June 5, 2025

**Re: M15E021G (SWQ-2025-00024) Comments Response Letter**  
**McDonald's 2000 Gibson Blvd. SE**  
**Langan Project No.: 520088901**

Thank you for taking the time to review the Erosion and Sediment Control Plan for the McDonald's restaurant located at 2000 Gibson Blvd. SE. We have addressed your comments as follows:

# EROSION CONTROL PLAN

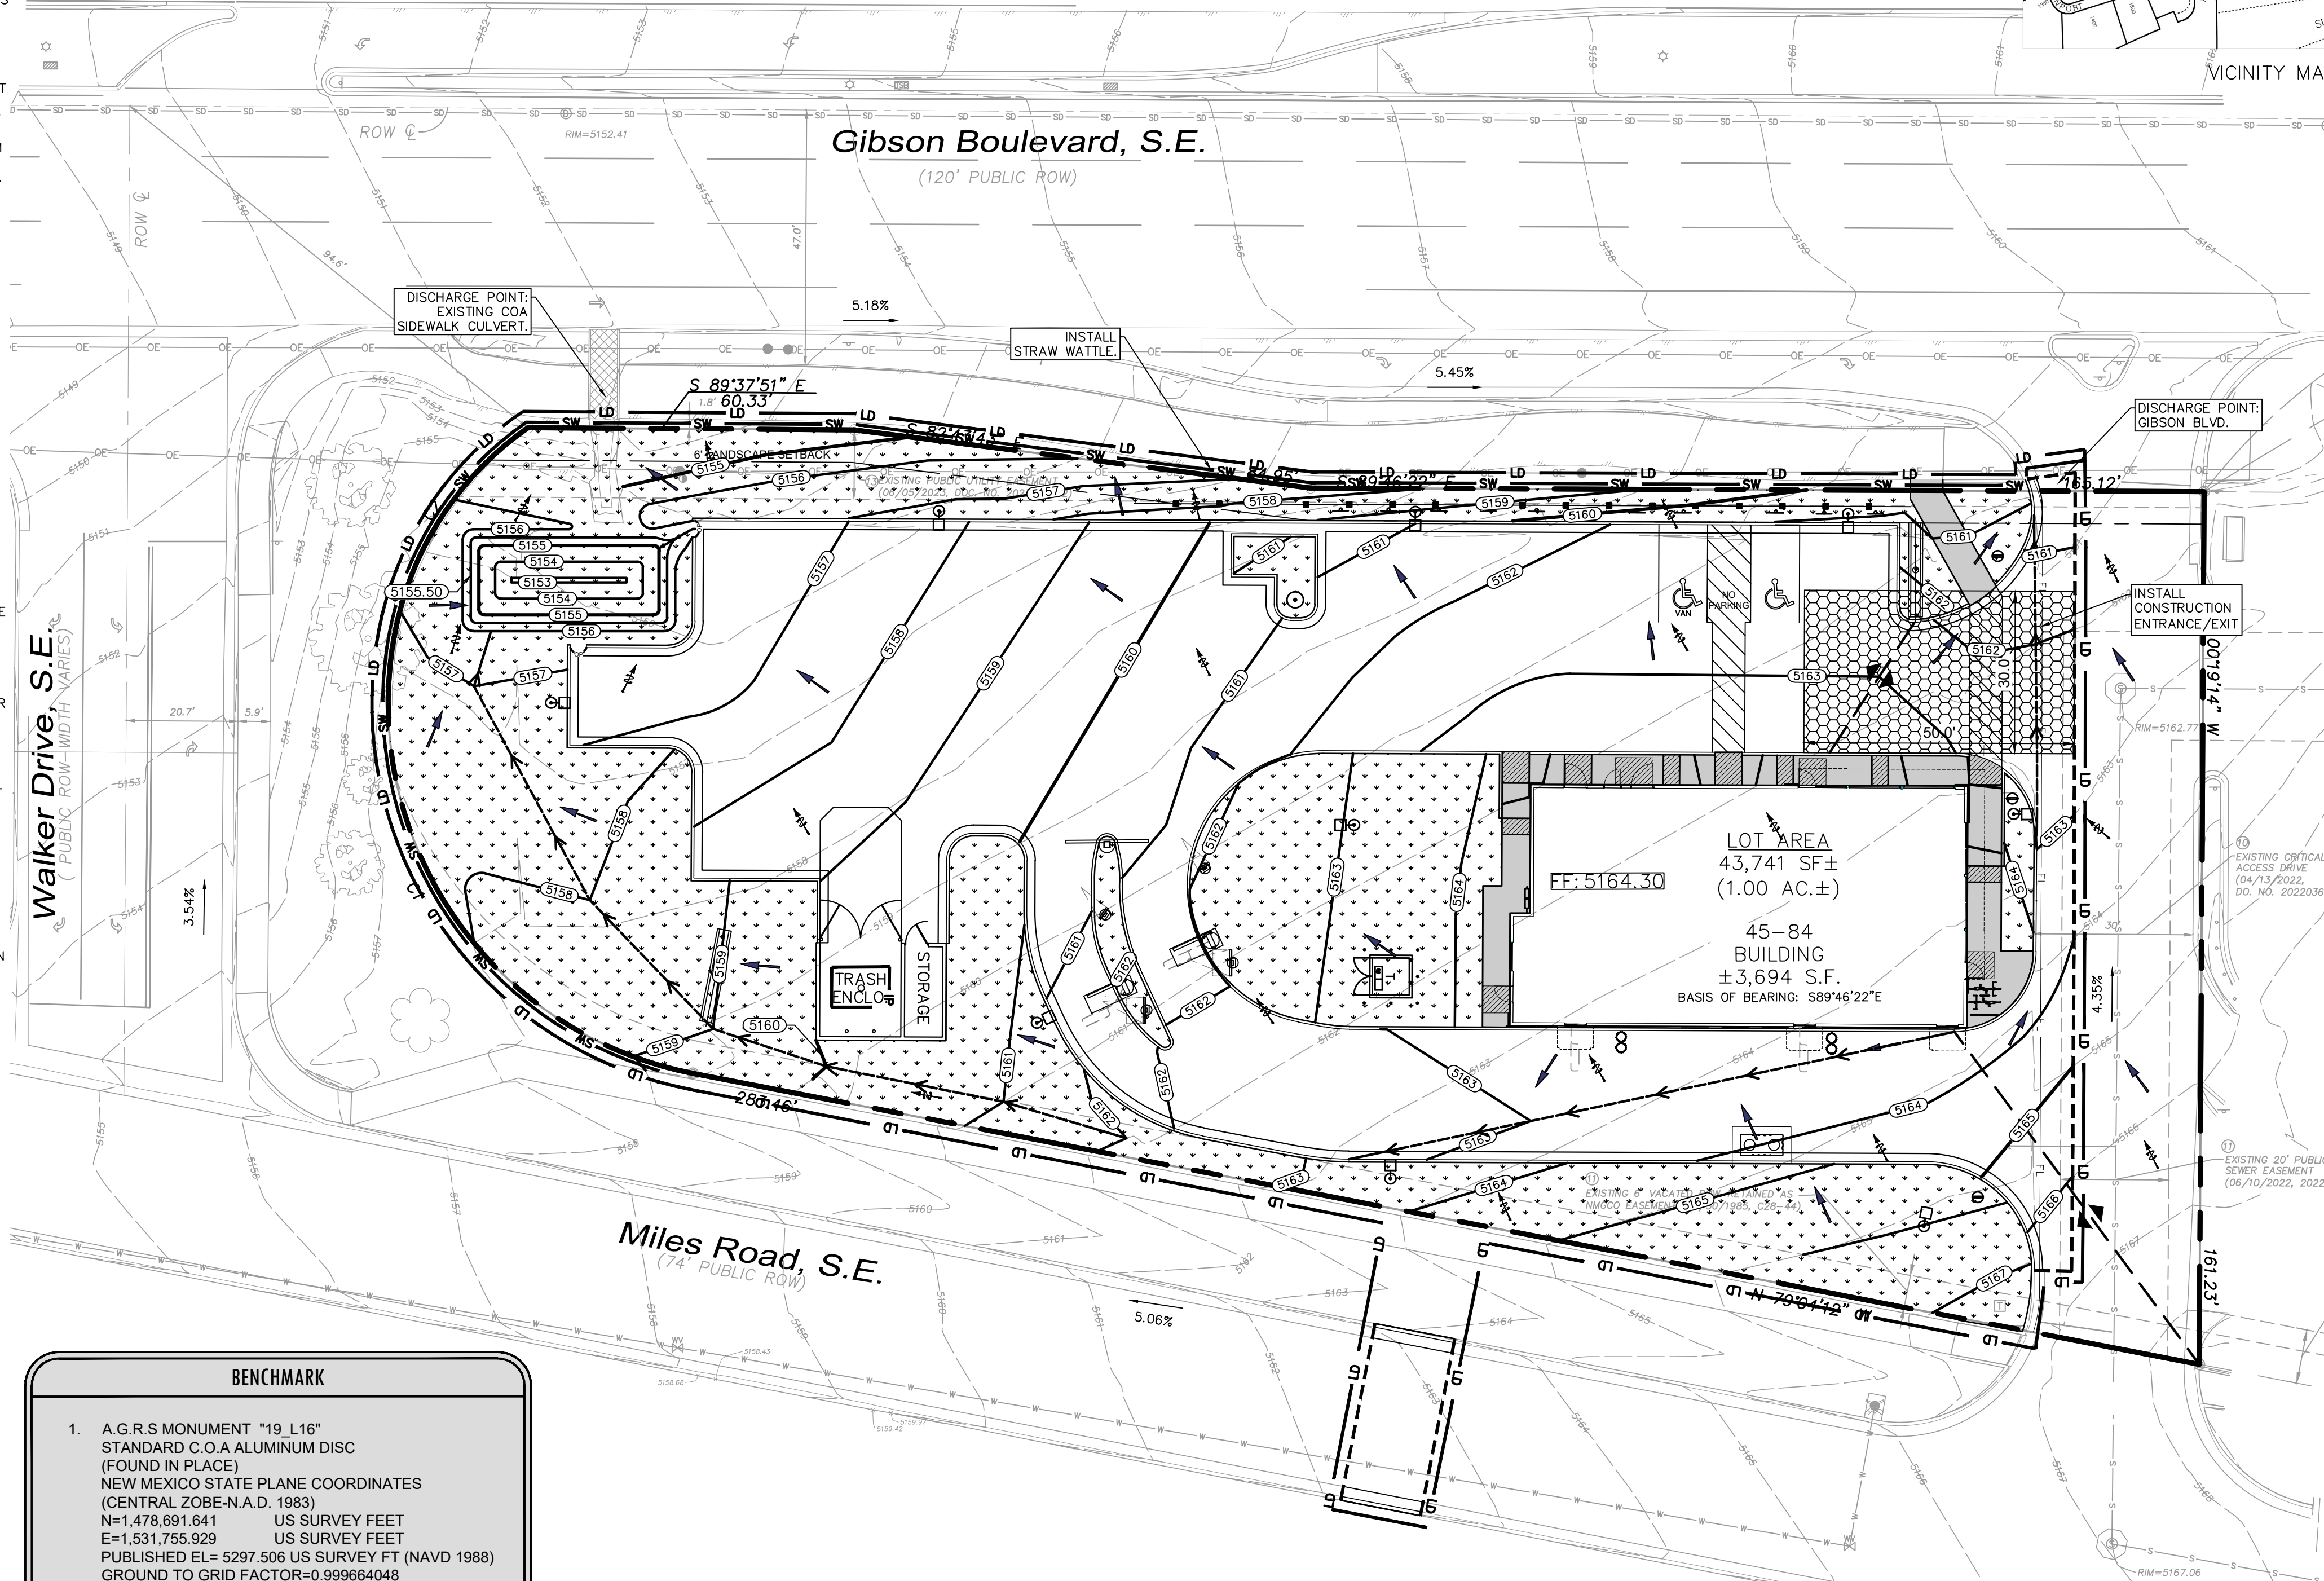
- 2) Add a temporary diversion berm to the ESC Plan along the north edge of the proposed parking lot to divert onsite flows into a temporary sediment trap sized to retain 3,600 cubic feet per acre or all of the excess precipitation from the 2-year storm, as per CGP 2.2.12. Add the berm construction to the sequence of construction as one of the first items, simultaneously with the demolition of the existing pavement. Add the removal of the berm to the sequence after the C&G is constructed along the north side of the parking lot.

- 3) A temporary sediment trap must be constructed upstream of the concentrated discharge point as one of the first items of construction, at the same time as the existing pavement demolition. The temporary sediment trap will be located in the same area as the permanent stormwater quality pond. However, the required size of the temporary sediment basin is based on significantly more precipitation than the permanent pond, so it will require a larger area, potentially overlapping with a portion of the parking lot. Include design calculations, construction details, and specifications for the temporary sediment

- 5) The wattle on the north edge of the site isn't "on contour," so it isn't in keeping with standard engineering practice. Even though most of the drainage area will be diverted to the temporary sediment trap by the temporary berm, the wattle isn't a sufficient control if it isn't installed according to standard practice. Please consider establishing the final grade in the area below the berm and providing immediate final stabilization after grading, rather than using wattle. Final stabilization isn't specified on the ESC Plan for either the SWQ Pond or for the slope, but "Slope & Pond Stabilization per City Standard Specification 1013" is appropriate, and the timing of the slope stabilization should be identified early in the sequence of construction.

EROSION CONTROL PLAN

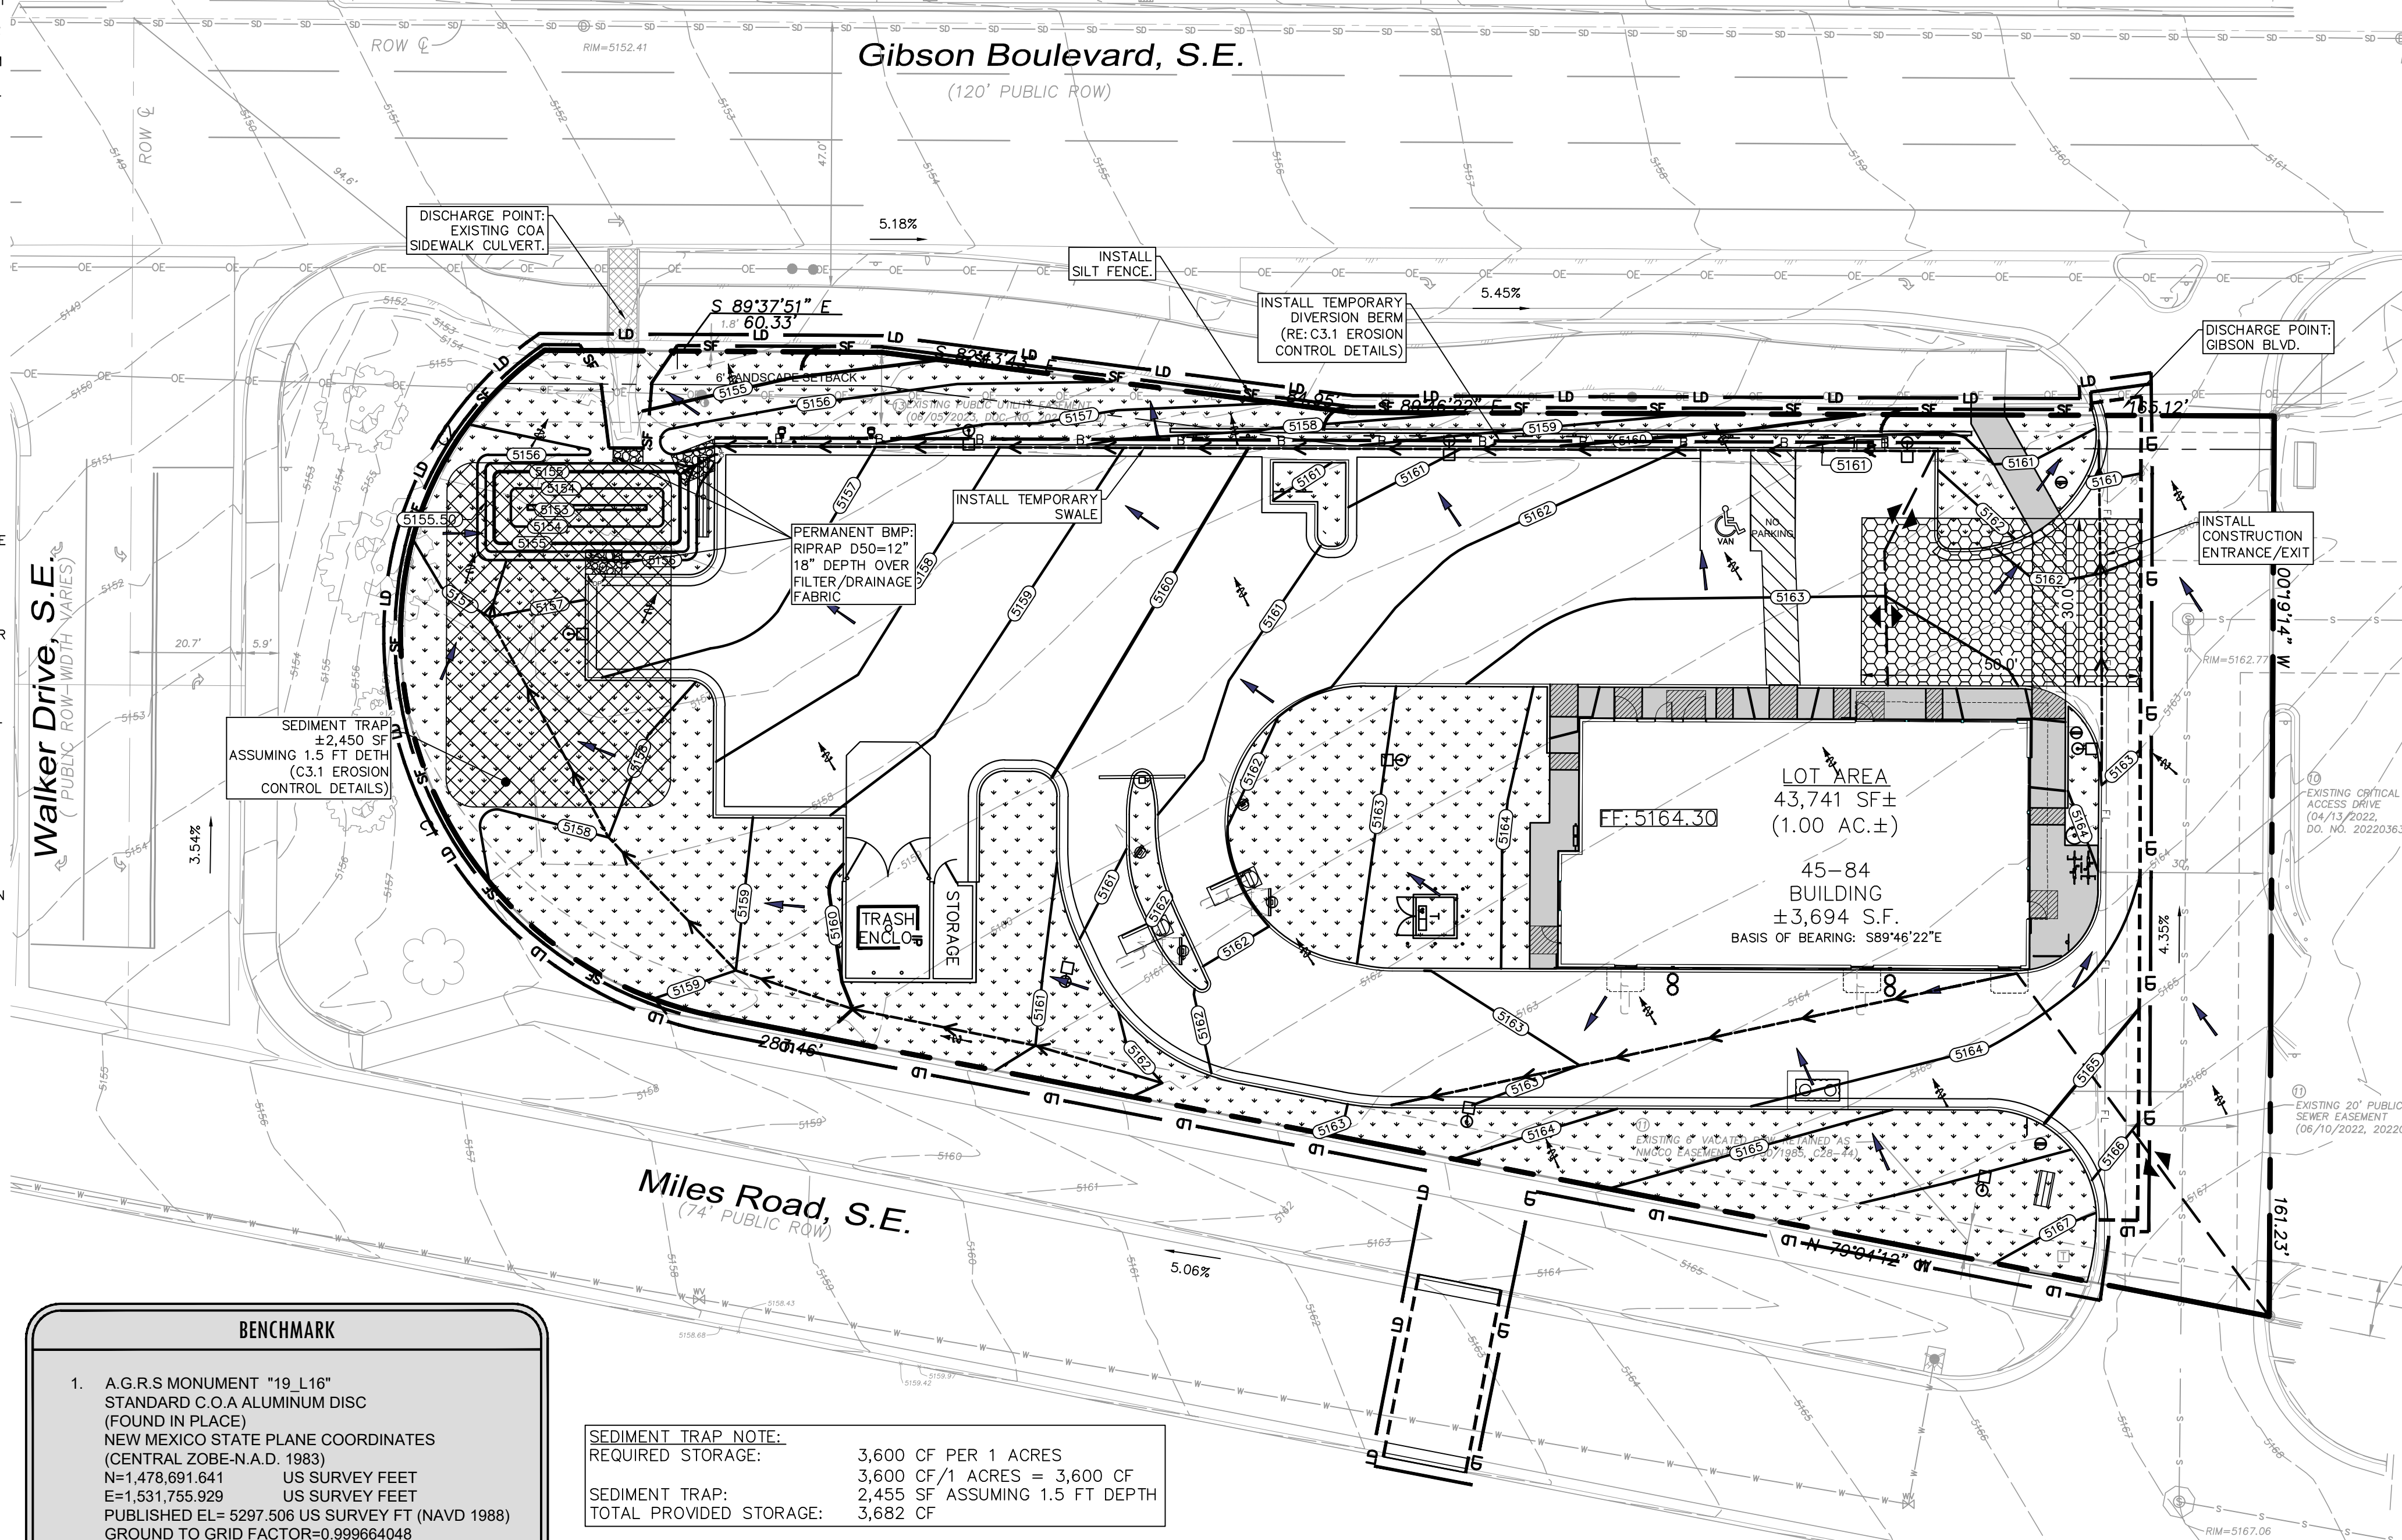
- a. Add a description of undisturbed and pre-construction ground cover (CGP 7.2.4.e) to the ESC Plan.
  - b. Soil information – add a table with name type, particle sizes, and Erodibility factor (CGP 2.1.1).

- c. Identify the existing and proposed drainage patterns of this site and its "Discharge Point" per CGP 7.2.4.f.
  - [Pre-construction description has been added near the vicinity map. Soil information has been added under the Acreage Summary. The Discharge points have been labeled.](#)

trap in accordance with CGP 2.2.12 and standard engineering practice per CGP 2.1.2 and CGP 9.6.1 in the ESC Plan resubmittal. Add the sediment trap construction as the first item in the sequence of construction, and its removal as the last item after the rest of the site is constructed and stabilized.

- 4) Specify both temporary and permanent stabilization at the discharge point to prevent erosion per CGP 2.2.1.b and 2.2.11.
- Temporary and permanent stabilization have been added to the plan at the discharge point.

- [A temporary diversion berm and temporary sediment trap have been added to the plan. The berm construction and removal have been added to the erosion control sequence.](#)

- A temporary sediment trap has been added and calculations have been provided. The details have also been added. The construction and removal have been added to the erosion control sequence.

- Straw wattle has been changed to a silt fence and J-hooks have been added along the silt fence. Final stabilization is specified on the Landscape Plan, and this has been included in this resubmittal.
